Norfolk Boreas Offshore Wind Farm

EXQ2: NNDC RESPONSE TO QUESTIONS ISSUED ON 12 FEBRUARY 2020

NORTH NORFOLK DISTRICT COUNCIL
(INTERESTED PARTY REF: 20022969)

25 FEB 2020

Appendix F - COLBY ROAD (CHURCH ROAD), NORTH OF BANNINGHAM - SITE PLAN AND PHOTOGRAPHS

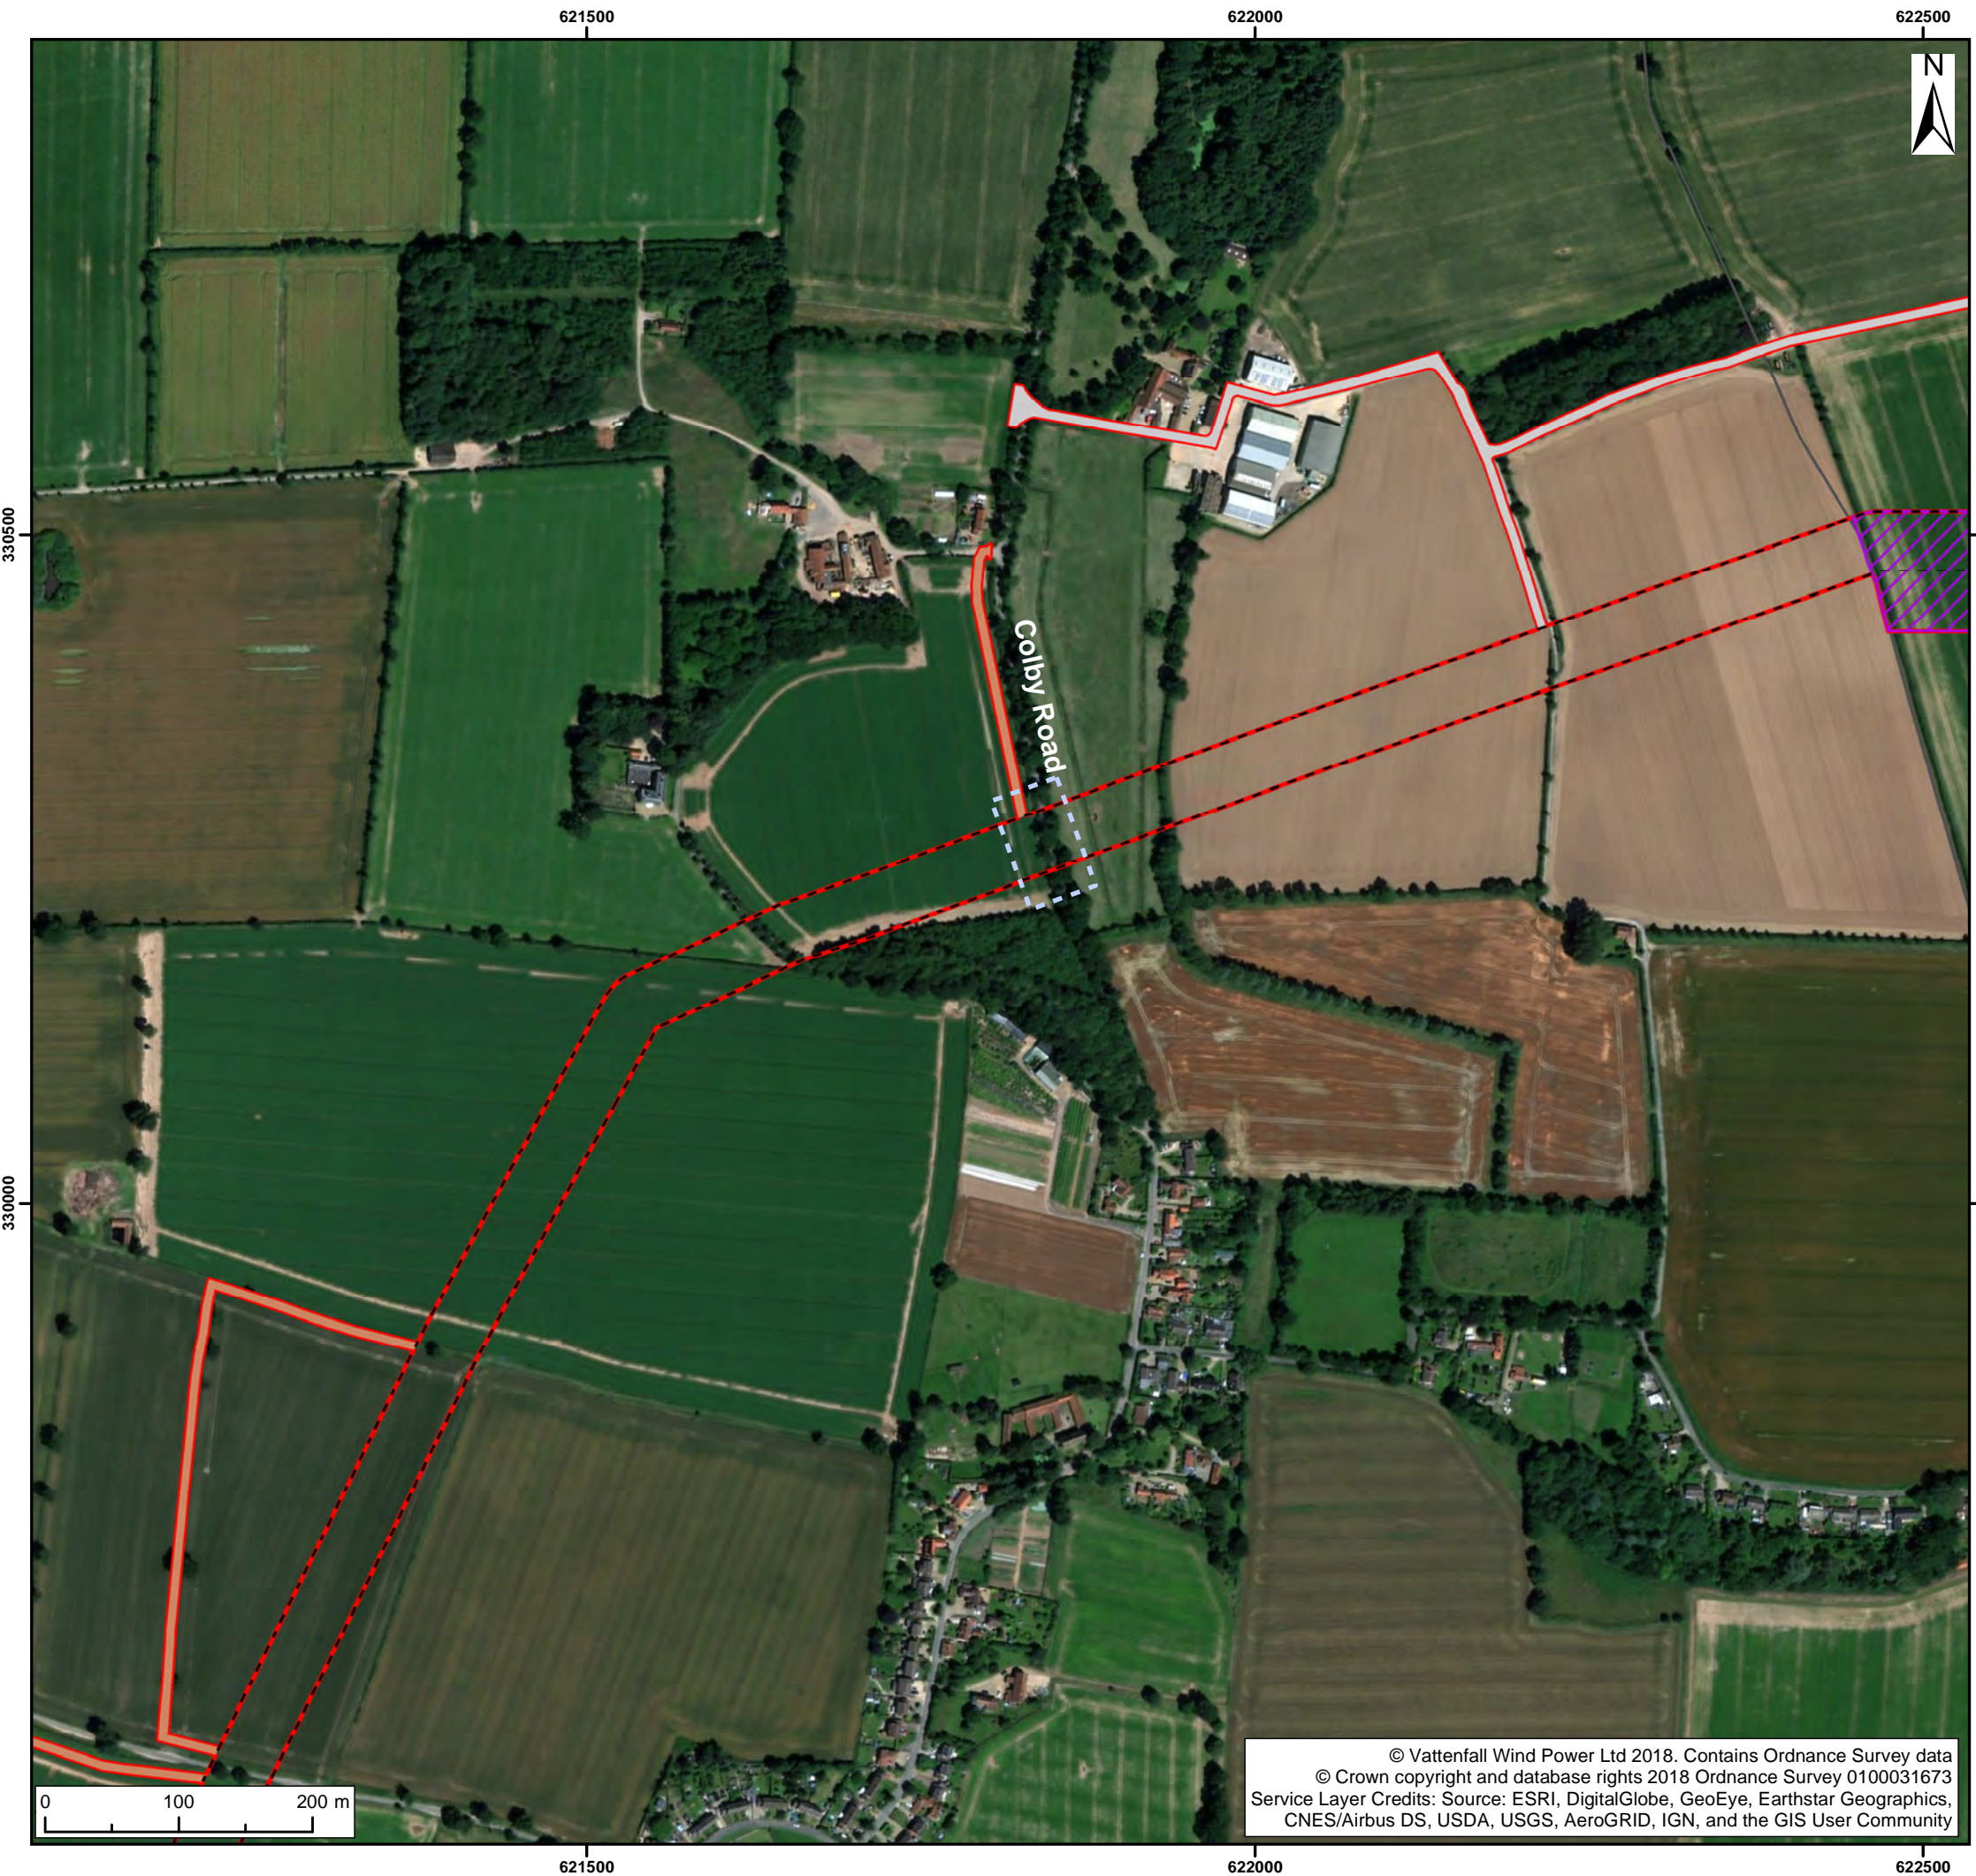
12. Onshore construction effects			
12.0 Cable corridor and ducting			
Q2.12.0.3	North Norfolk District Council	<p>Trenchless crossing at Church Lane, Colby:</p> <p>NNDC to consider its position regarding the pros and cons of a trenchless crossing at Church Lane, Colby in response to the Applicant's explanation [REP4-017].</p>	<p>NNDC has considered the applicant's Clarification Note submission in relation to trenchless crossing at Church Lane, Colby [REP4-017]. NNDC notes the position of the applicant as set out across paragraphs 32 to 44 of this document.</p> <p>In the context of considering this document, the ExA should be aware of the Important Hedgerows Plan prepared by the applicant [APP-018] where sheet 13 of 42 relates to the Colby Road area. This plan identifies six 'Important Hedgerows' affected by the project in this area alone.</p>

<p>Whilst NNDC consider that the applicant is perhaps seeking to overplay the negative HGV and construction traffic impact consequences associated with trenchless crossing compared against open cut trenching, it is nonetheless recognised by NNDC that there would be greater construction associated impacts for trenchless crossing. However, these construction related impacts would occur over a relatively short-term duration compared against the operational lifespan of the project and do have to be carefully weighed against the positive benefits of trenchless crossing including avoiding removal of sections of six Important Hedgerows and roadside trees which are an intrinsic landscape feature of the rural character of Colby Road.</p> <p>In discussing this matter with the applicant, particularly with regard to alternative access points, NNDC has suggested consideration of an alternative vehicular access point to the north of the proposed cable corridor - see annotated plan of the proposal attached at Appendix B. This would be located at a point where there is an existing break in the tree line on the western side of Colby Road at the entrance to Hall Farm and Hall Farm Cottages. Existing access tracks could be partly used to form a new works access entrance with no loss of trees on this side of the road. On the eastern side of Colby Road, a new access could be created through the existing hedge. Whilst this may require removal of one or two semi-mature trees, the advantage of using this location is</p>

<p>that replacement trees (and hedging) could be planted where gaps are created because the access would fall outside of the permanent easement area. These two accesses could allow new running track to be laid which will enable access to the trenchless crossing under Colby Road and thus negating the need to remove sections of three Important Hedgerows No.77, 78 and 79..</p> <p>NNDC fully recognise that this alternative proposal carries additional considerations, namely those related to impacts to residents living nearby at Colby Hall Farm, Hall Farm, Hall Farm Cottages and Banningham Hall, amongst others who use the existing road network. These impacts have not been assessed by the applicant and fall outside the red line area of the DCO application.</p> <p>Ultimately it is a matter of planning judgment for the ExA. The applicant is reluctant to consider alternatives beyond what they have considered within the ES, but this is not in itself justification for the existing option they are pursuing. What is at stake here is avoiding disturbance of three out of six Important Hedgerows along this part of the route as well as the integrity of the tree lined road. The character of Colby Road would be permanently affected by the open cut trenching option proposed by the applicant with permanent easements preventing replacement trees being planted in the same or similar locations. Acknowledging that there will be some additional short term noise disturbance to</p>

ExQ2 Question No.	Question to	Question	North Norfolk District Council Response
			neighbouring residents from the alternative proposed by NNDC, the benefits of saving the trees and Important Hedgerows are considered to more than outweigh any temporary harm to residential amenity.
